# Building Details

**9225 Oto Circle**

# Site Plan\_v1-redline.pdf Markup Summary

Building Details

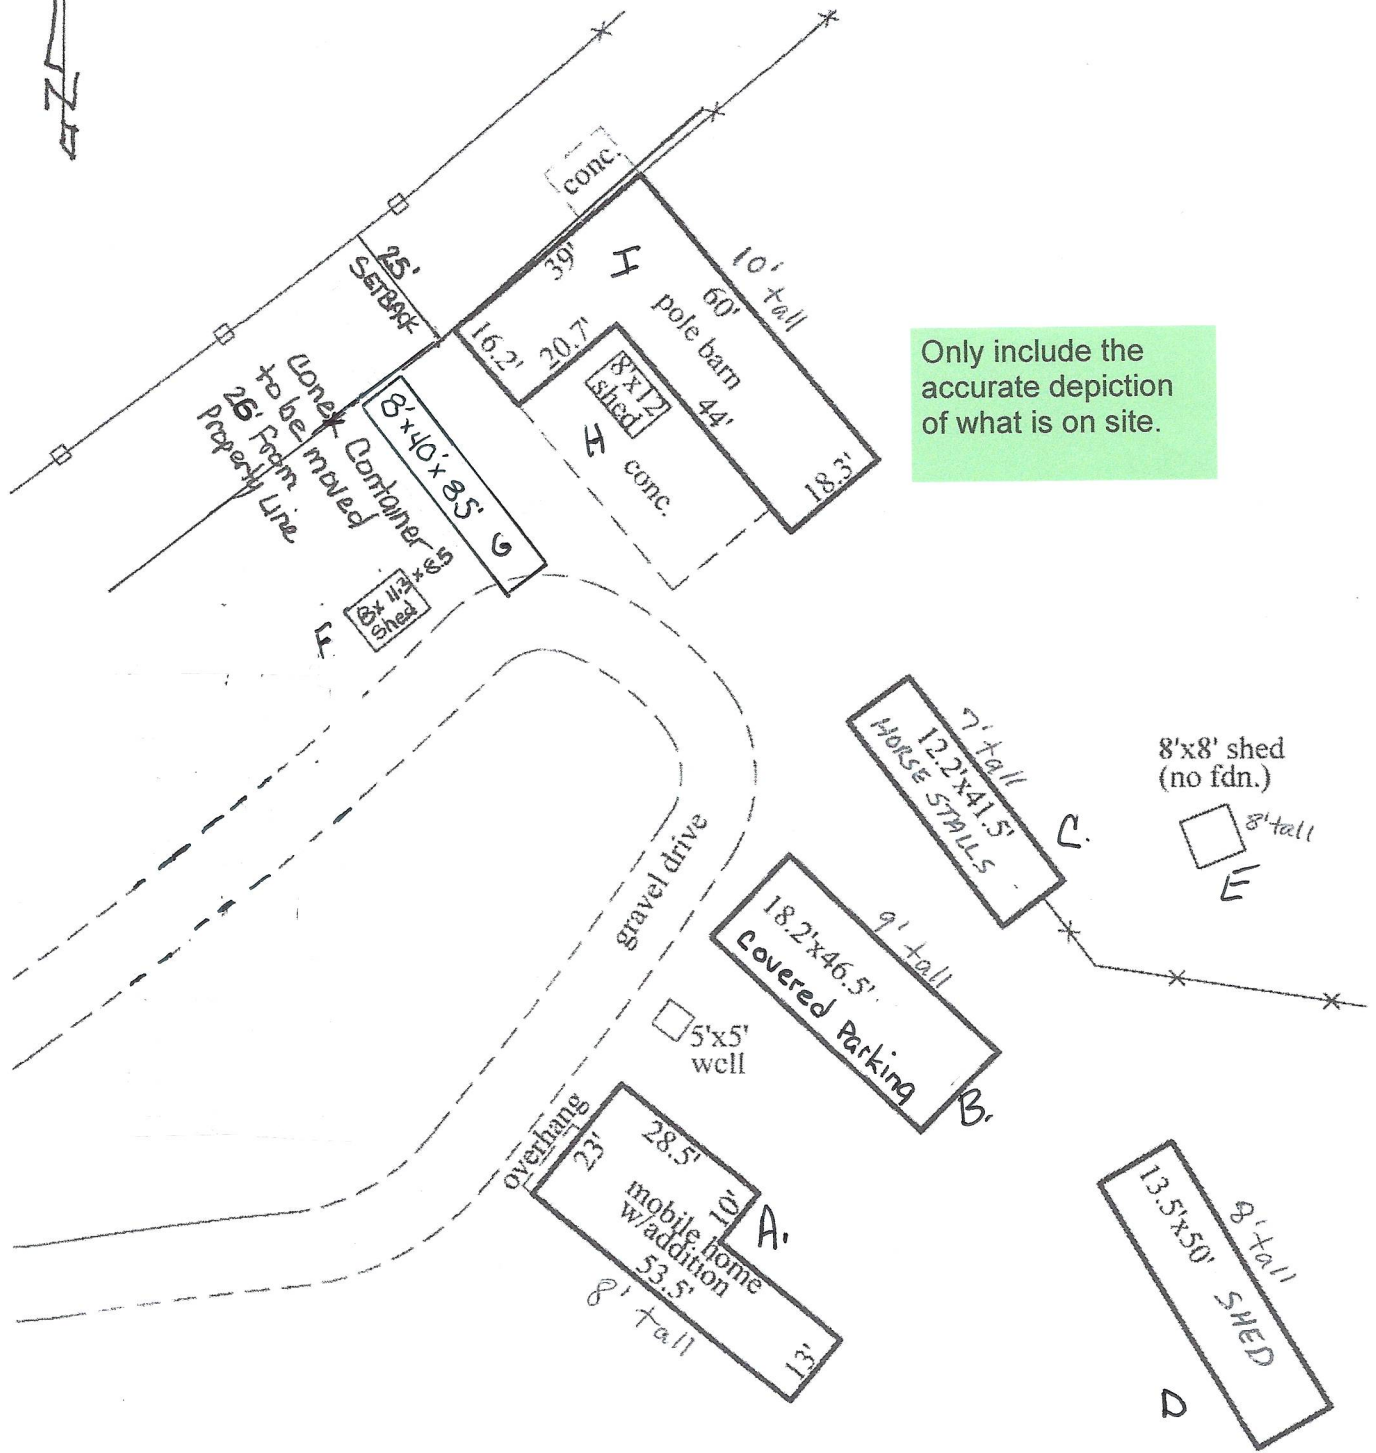
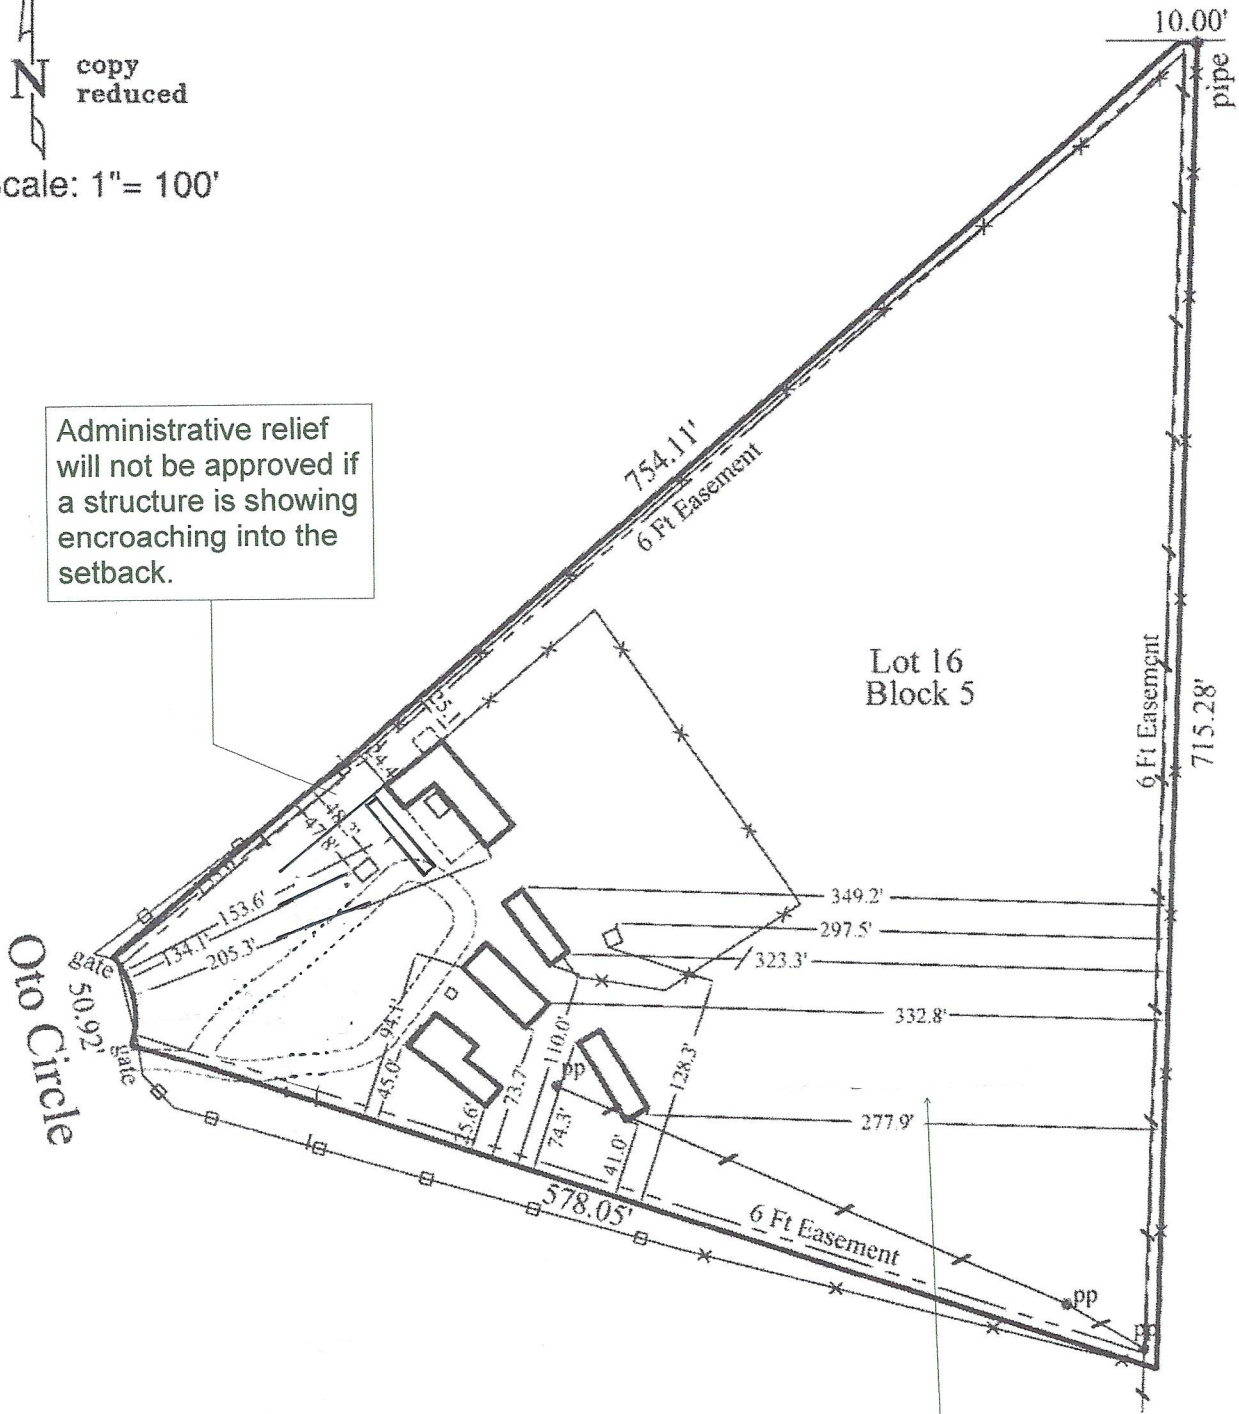
Administrative relief will not be approved if a structure is showing encroaching into the setback.

> Only include the accurate depiction of what is on site.

Only include the accurate depiction of what is on site.

Page 2 should be attached or this note should be eliminated.
